# M5 Junction 10 Improvements Scheme

Statement of Common Ground

Historic England

TR010063 - APP 8.6

Project Title		M5 Junction 10 Improvements Scheme	
Drawing Title		FIGURE 11-1 DESIGNATED HISTORIC ENVIRONMENT ASSETS	
Drawing Number		GCCM5J10 - ATK - EHR ZZ - GS - GI - 000001	
Original Size: A3	Scale: 1:25,000	Project Ref: 5214106	Sheet: 1 of 1
Location	Type	Role	Number
			P02

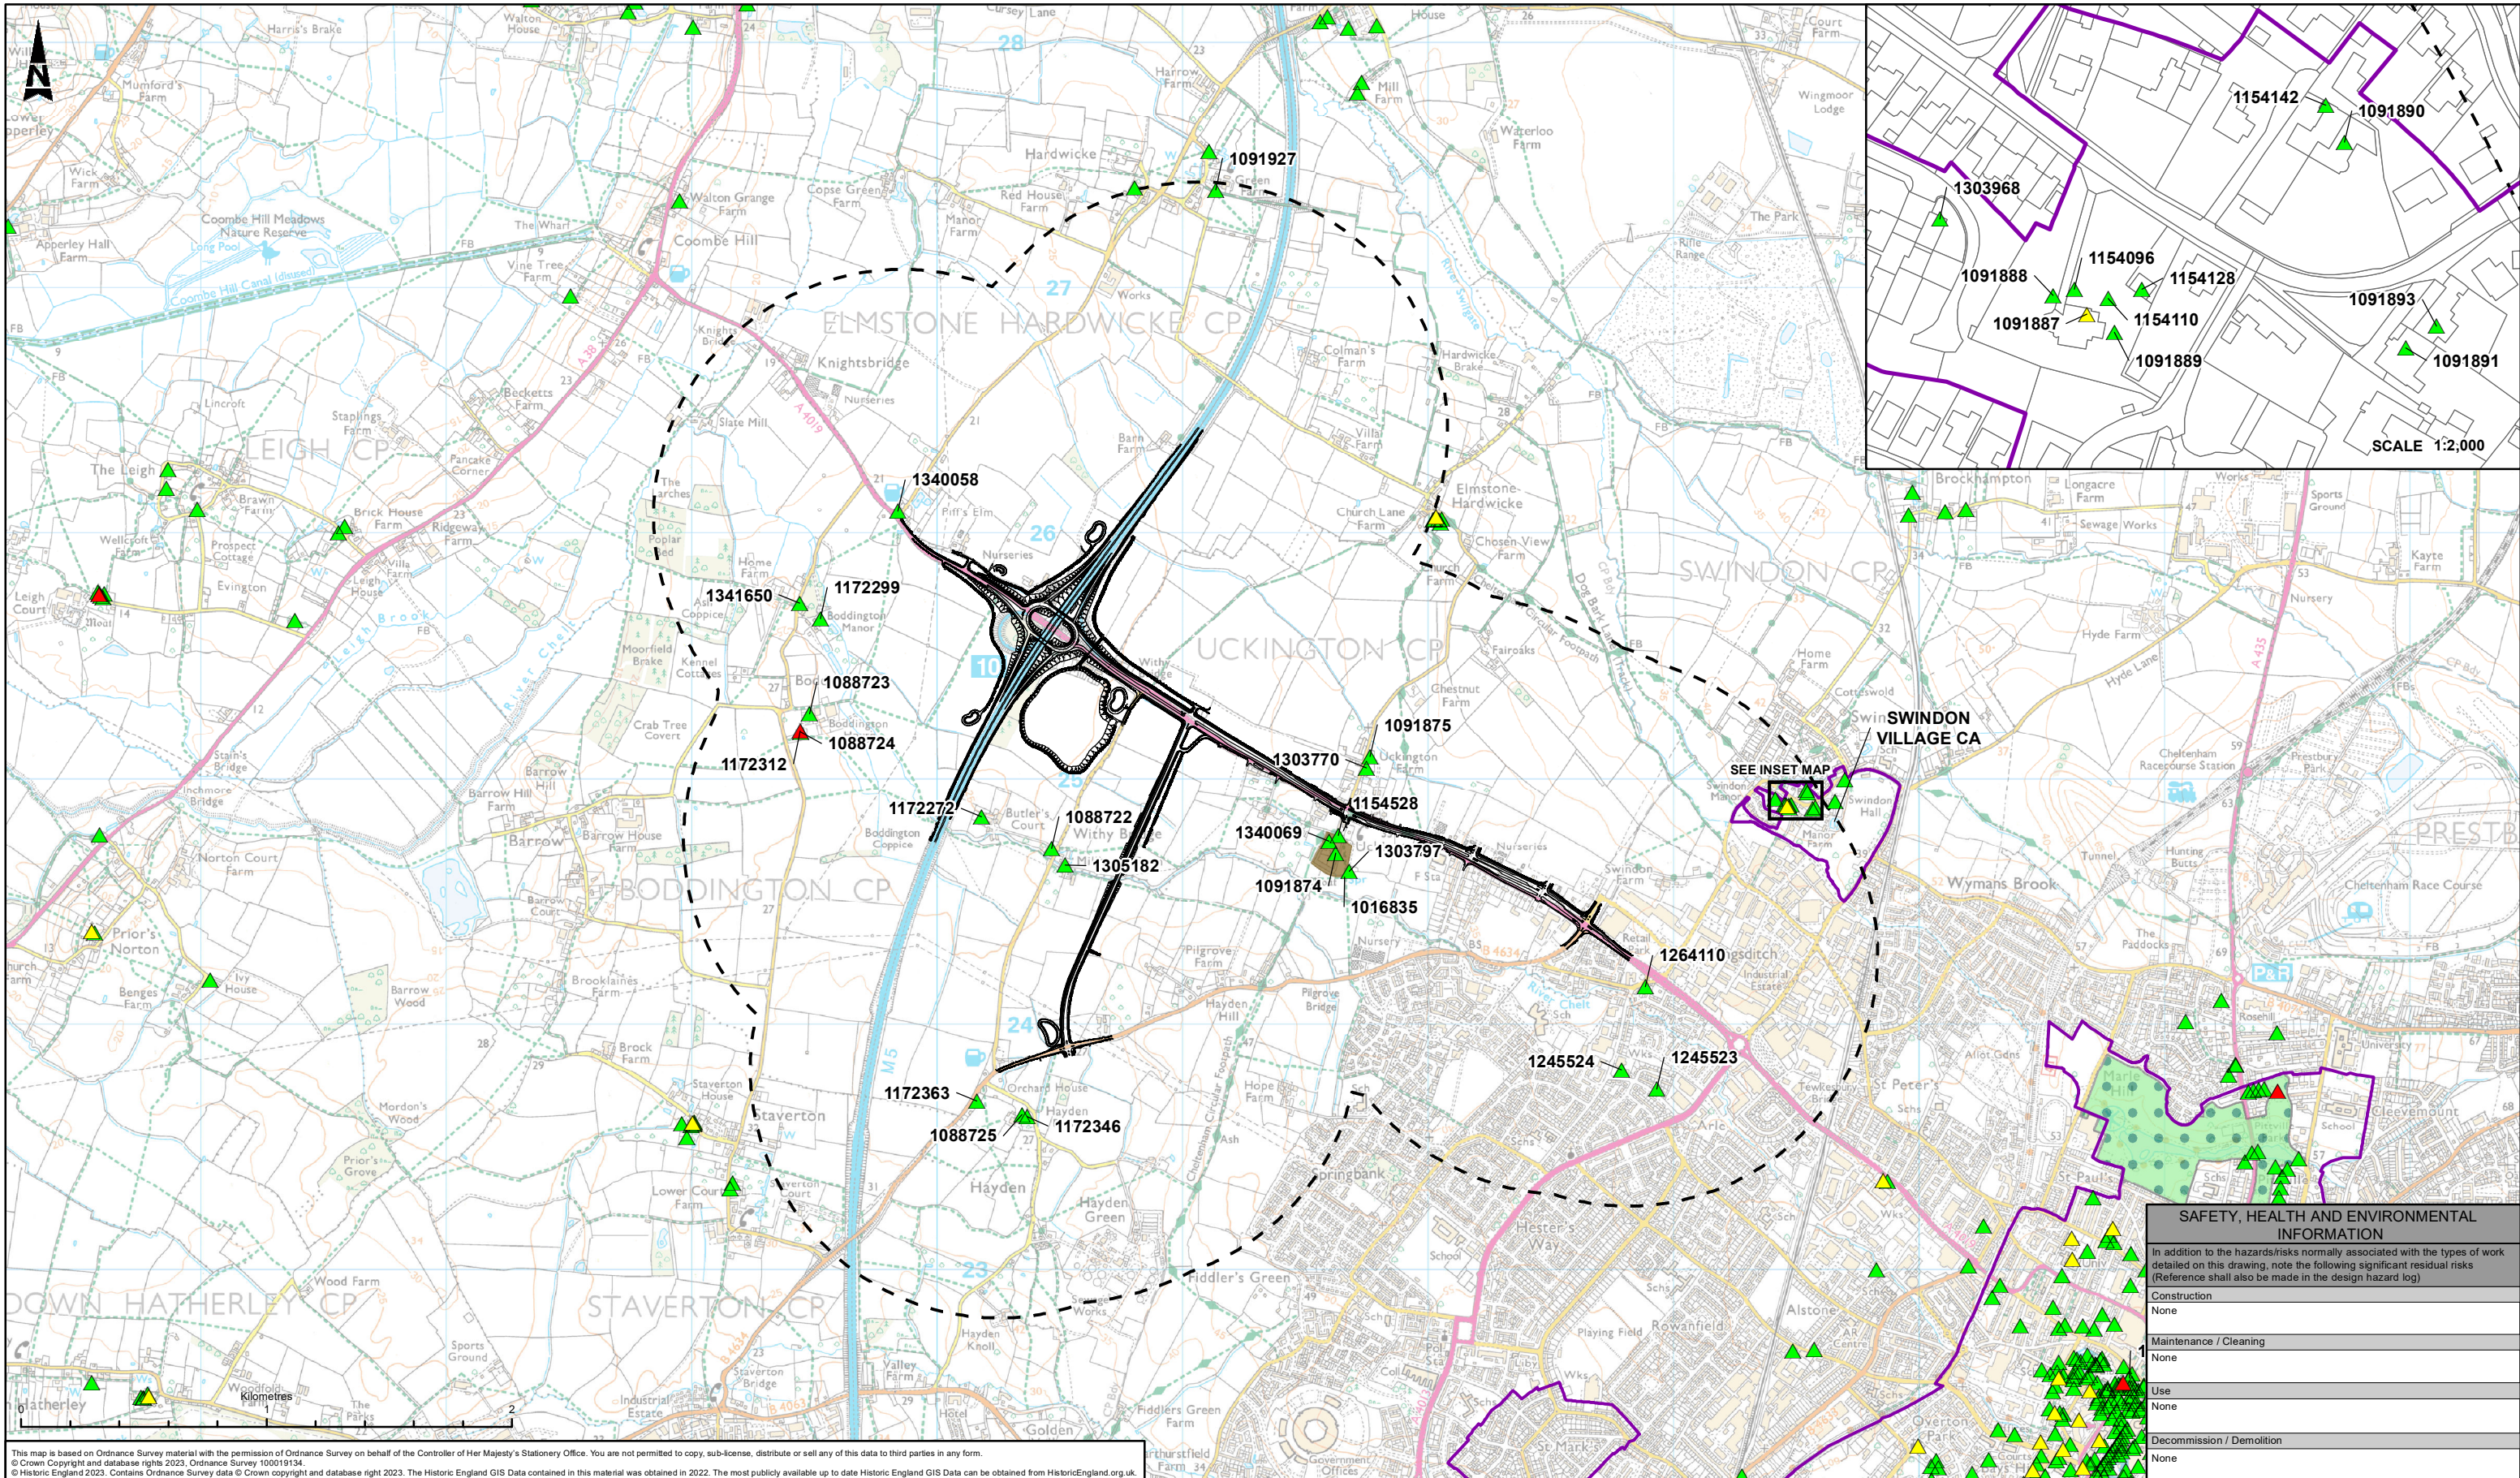
5. Air Quality			
6. Cultural Heritage			
6.1.	<p>Historic England in particular has concerns regarding the level of information provided regarding the highly designated heritage asset of Uckington Moated Site (a scheduled monument and several listed buildings). We feel that some aspects of the scheme in its current form will impact on and cause harm to the significance of the asset through a change in its setting, which contributes to its significance.</p>	<p>Following further work, it is proposed that the new link between Cooks Lane and Moat Lane and the creation of passing bays along Moat Lane be removed from the latest version of the design. This will reduce the proximity of the M5 Junction 10 Improvements Scheme to Moat House. An assessment of the setting of the Scheduled Monument and the Listed Buildings has been presented as part of the Environmental Statement.</p>

6.3.	Potential Impacts on Designated Heritage Assets The improvements to Junction 10 and the dualling of the A4091 will increase vehicle use of the road into Cheltenham. Close to the site at the end of Moat Lane there will be a signal-controlled junction, which will increase movement, noise and lighting on the approach to the moated site.	A setting assessment has been conducted for the designated assets at Moat House in order to understand how the surroundings contribute to the assets' significance. This has informed the ES. Early assessments of the study area resulted in changes to the original proposals for the junction improvements to minimise impacts on the setting of the designated assets at Moat House.

6.4.	The demolition of the three bungalows to the east of Moat Lane, along the A4091 will remove the current protection they give to the Moated site. They form a noise and visual barrier between the road and the Moated site. The increase in noise, fumes and potentially lighting will further urbanise this stretch of road. This change and the impact this causes needs to be included in Chapter 11 Cultural Heritage, of the Environmental Statement. The PEI report states that a setting study of the designated heritage asserts will be undertaken for the ES (PEIR Chapter 11 11.7.7). The PEIR, however, goes on to state that the setting of the Moated site is confined to its borders and that the scheme will not impact on its significance as a good example of a medieval moated site (PEIR Chapter 11 11.7.10 and 11.7.12). We do not agree with this	A setting assessment has been conducted for the designated assets at Moat House in order to understand how the surroundings contribute to the assets' significance. This has informed the ES, along with the results of the assessments on changes to air and noise conditions.
